RFI

RFI #: 177
Date: 8/6/2012
Job: EB-02 Keller Springs Lofts
Phone: 877-777-5115

Subject: A2 unit beams

RFI #: 166
Date: 7/5/2012
Job: EB-02 Keller Springs Lofts
Phone: 877-777-5115

SHEET NUMBER  
S2.01

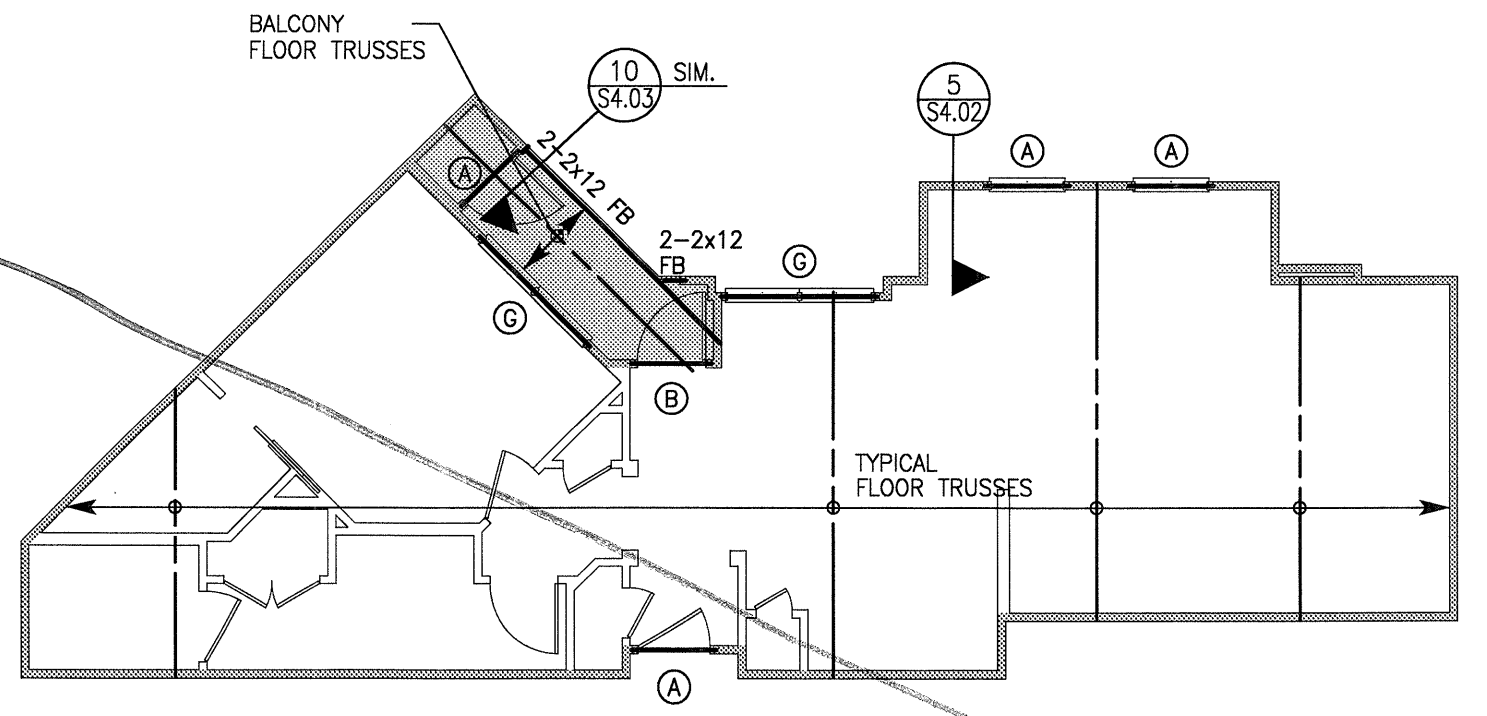
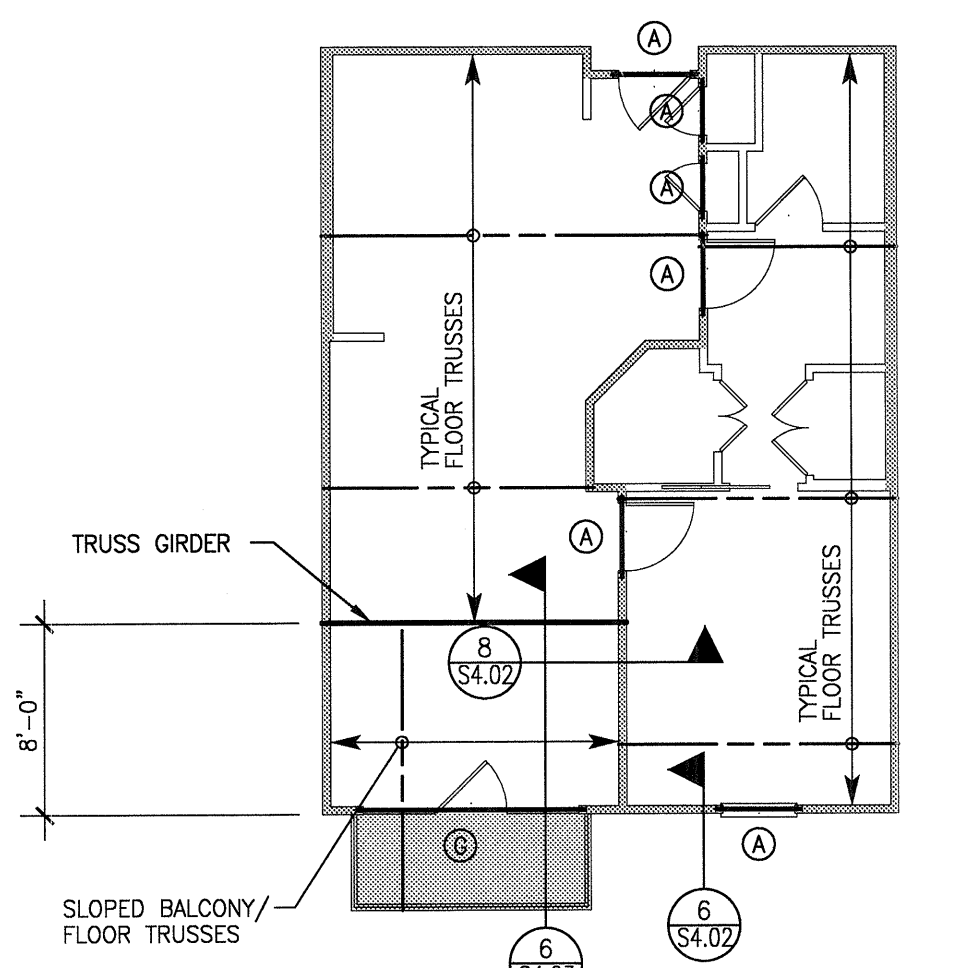
Request: **Date Required: 7/5/2012**
Can we use DFL in lieu of SYP for 2x12 headers?

Response:
number 1 douglas fir-larch is an acceptable substitute for the number 2 grade southern pine at the 2x12 headers

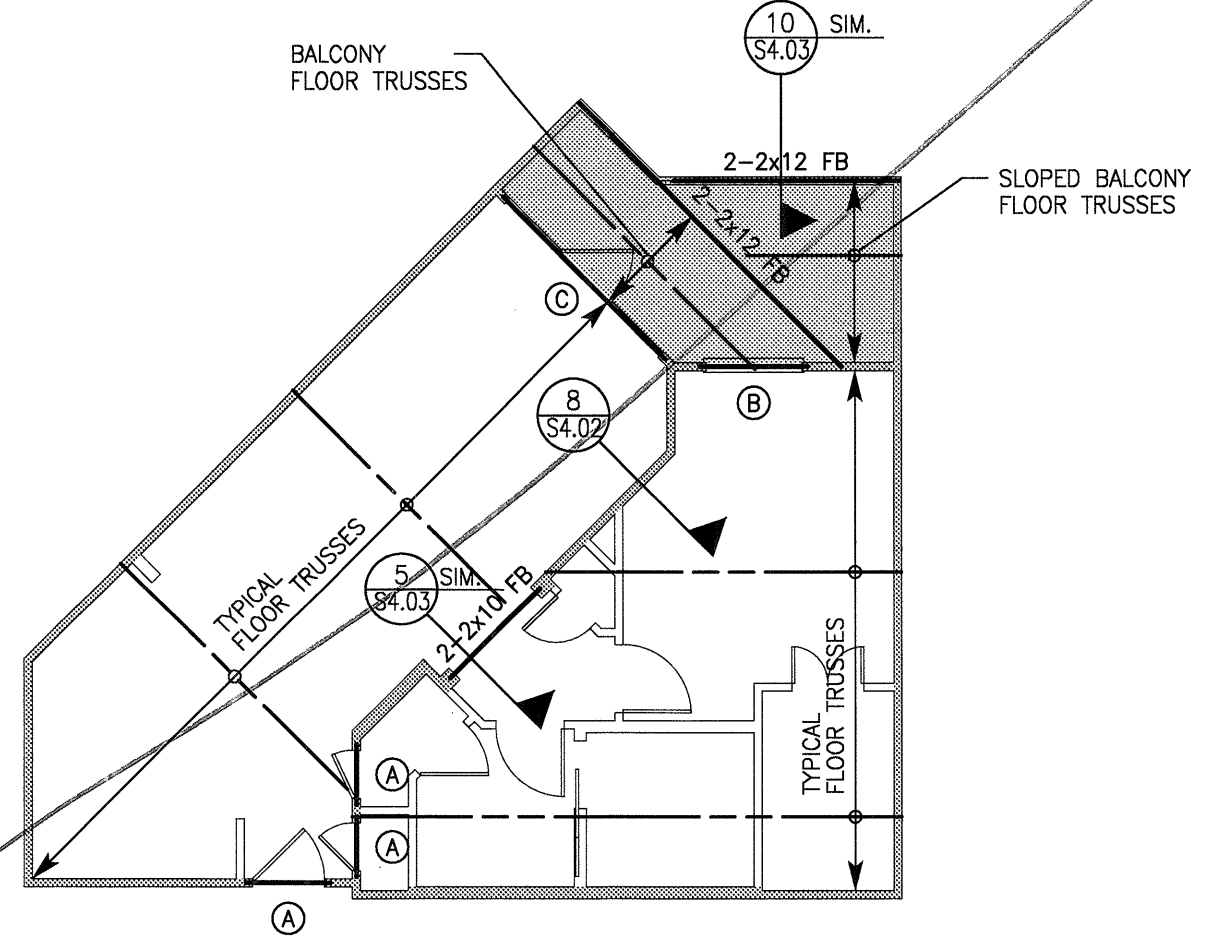
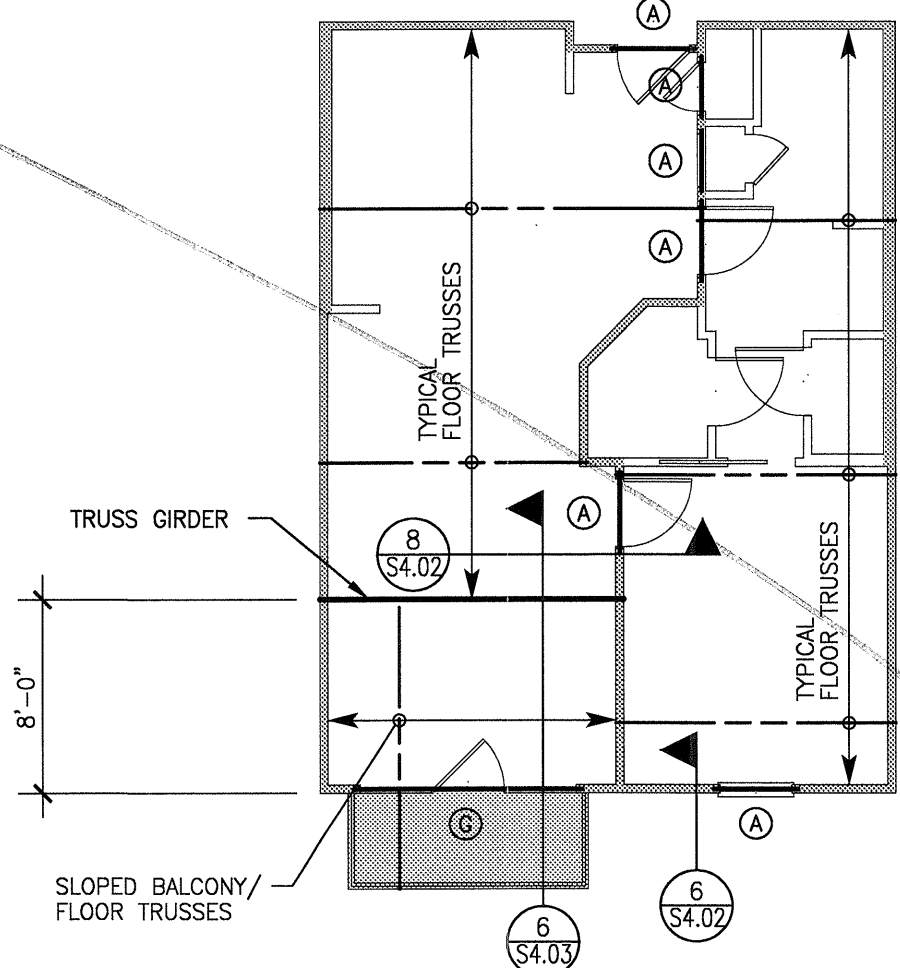
Request: **Date Required: 8/7/2012**
A2 BEAMS
The A2 units have a 2x12 FB that intersects another 2x12 FB at a 45degree angle. There is no hanger noted at these locations. Does this beam to beam connection need a hanger? Please refer to page S2.01 details #9 #10 #11 and #12. If a hanger is needed can we use a SUR410 / SUL410 or a HSUR410 / HSUL410? I have spoken to the truss co and they have said they cannot tell us if a hanger is needed or what size it should be.

Response:
HSUR410/HSUL410 are acceptable.
